**From:** Michaela Gleave  
**Sent:** 02 March 2021 13:34  
**To:** Planning  
**Subject:** planning consultation on application 3/2021/0003 - Higher Greaves Barn

Re: planning application 3/2021/0003

Title	Proposed Site Plan elevations ISO		
Date	Dec 2020	Scale	1:200
Rev	0	Number	103
Drawn	SC

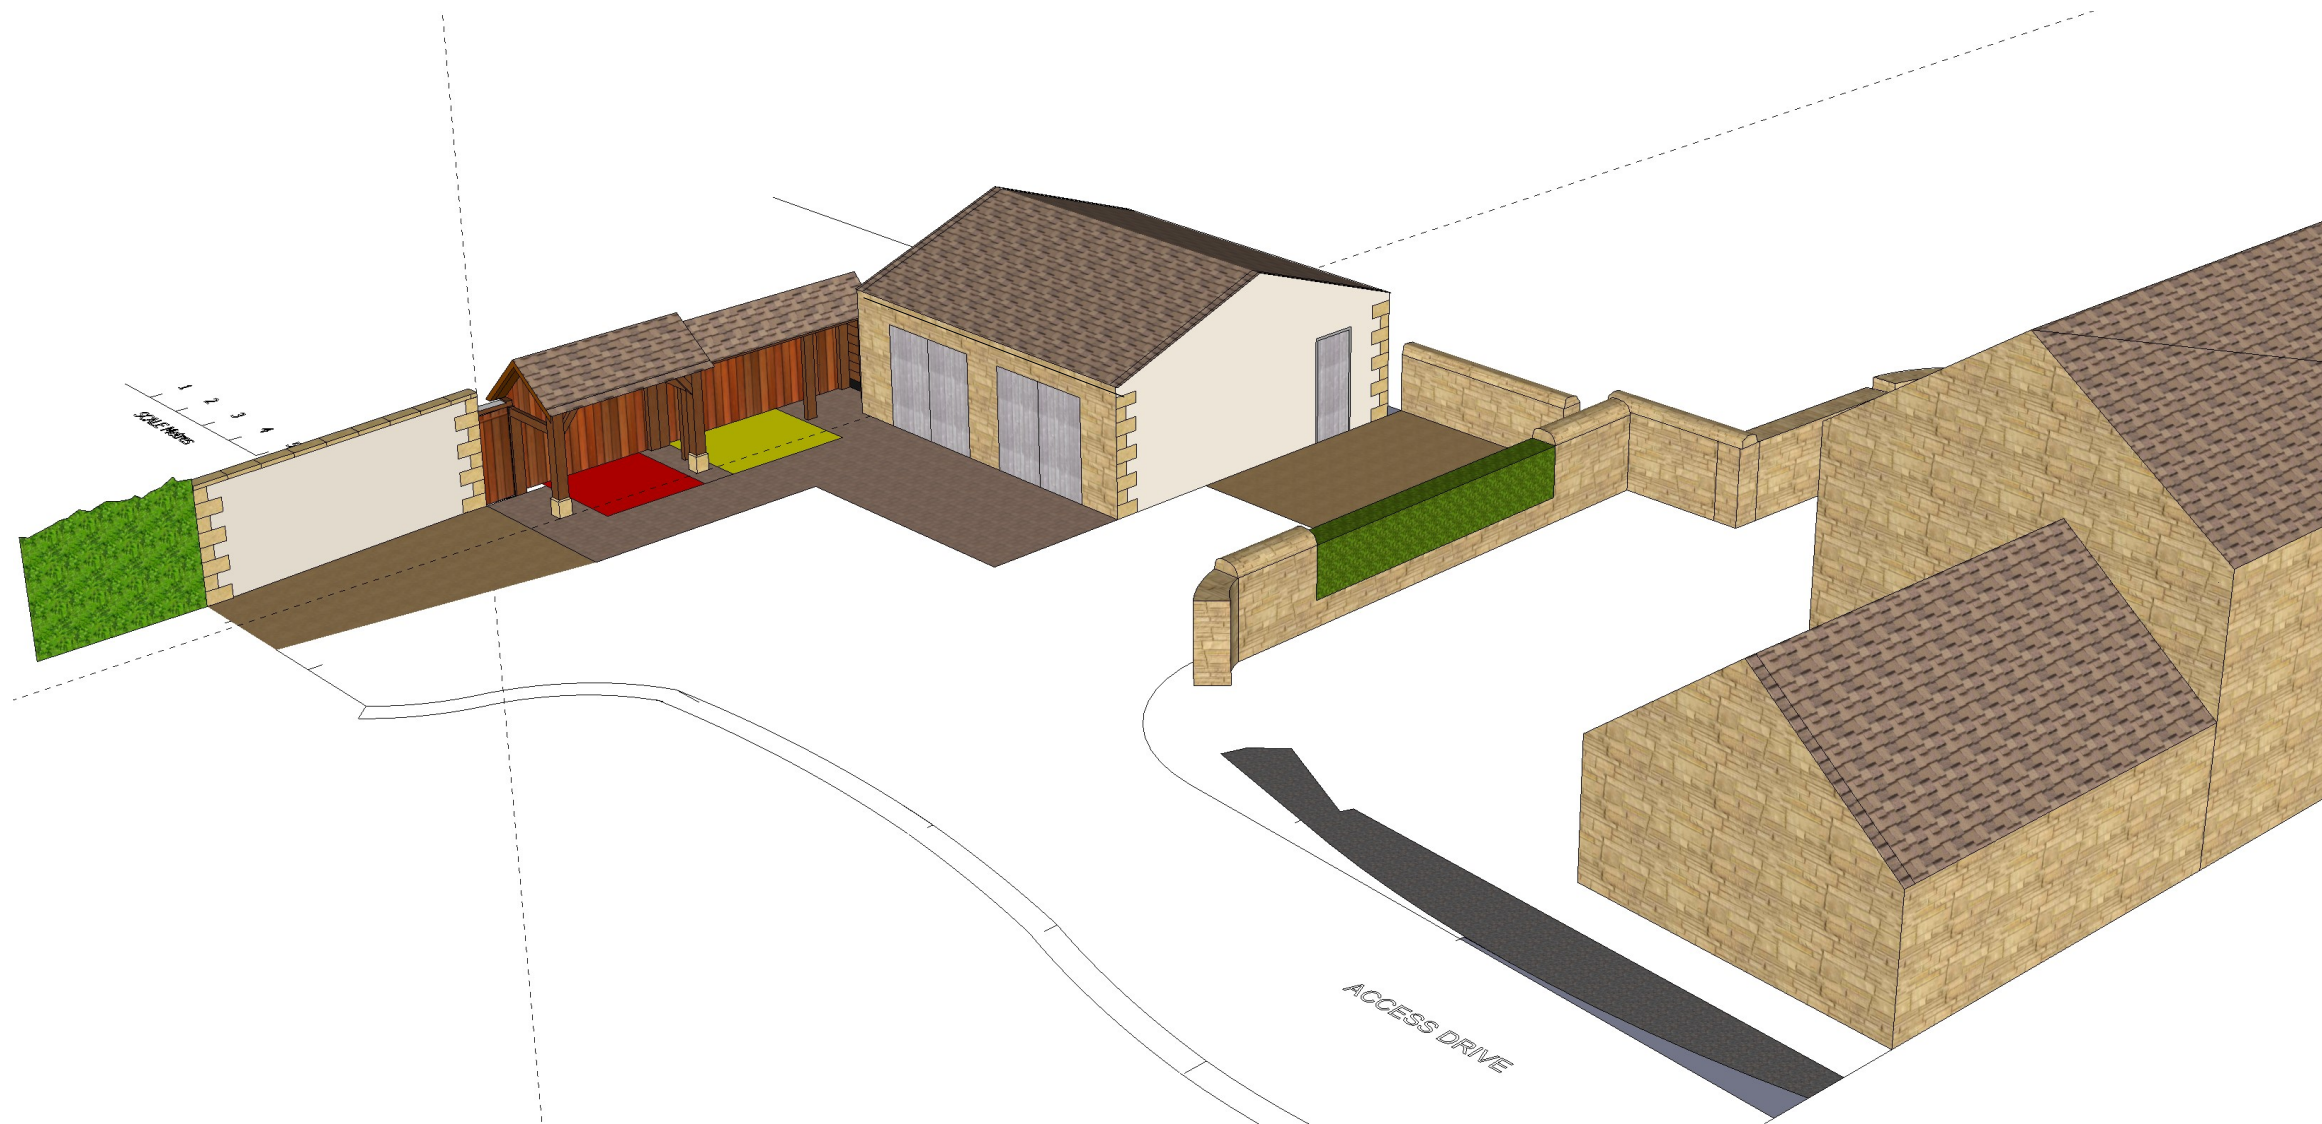
Environmental Health have been consulted due to the reference of reinforcing acoustic attenuation within the application. It is not considered that a wall in the location specified would significantly reduce any potential sources of noise pollution at the adjacent farm.
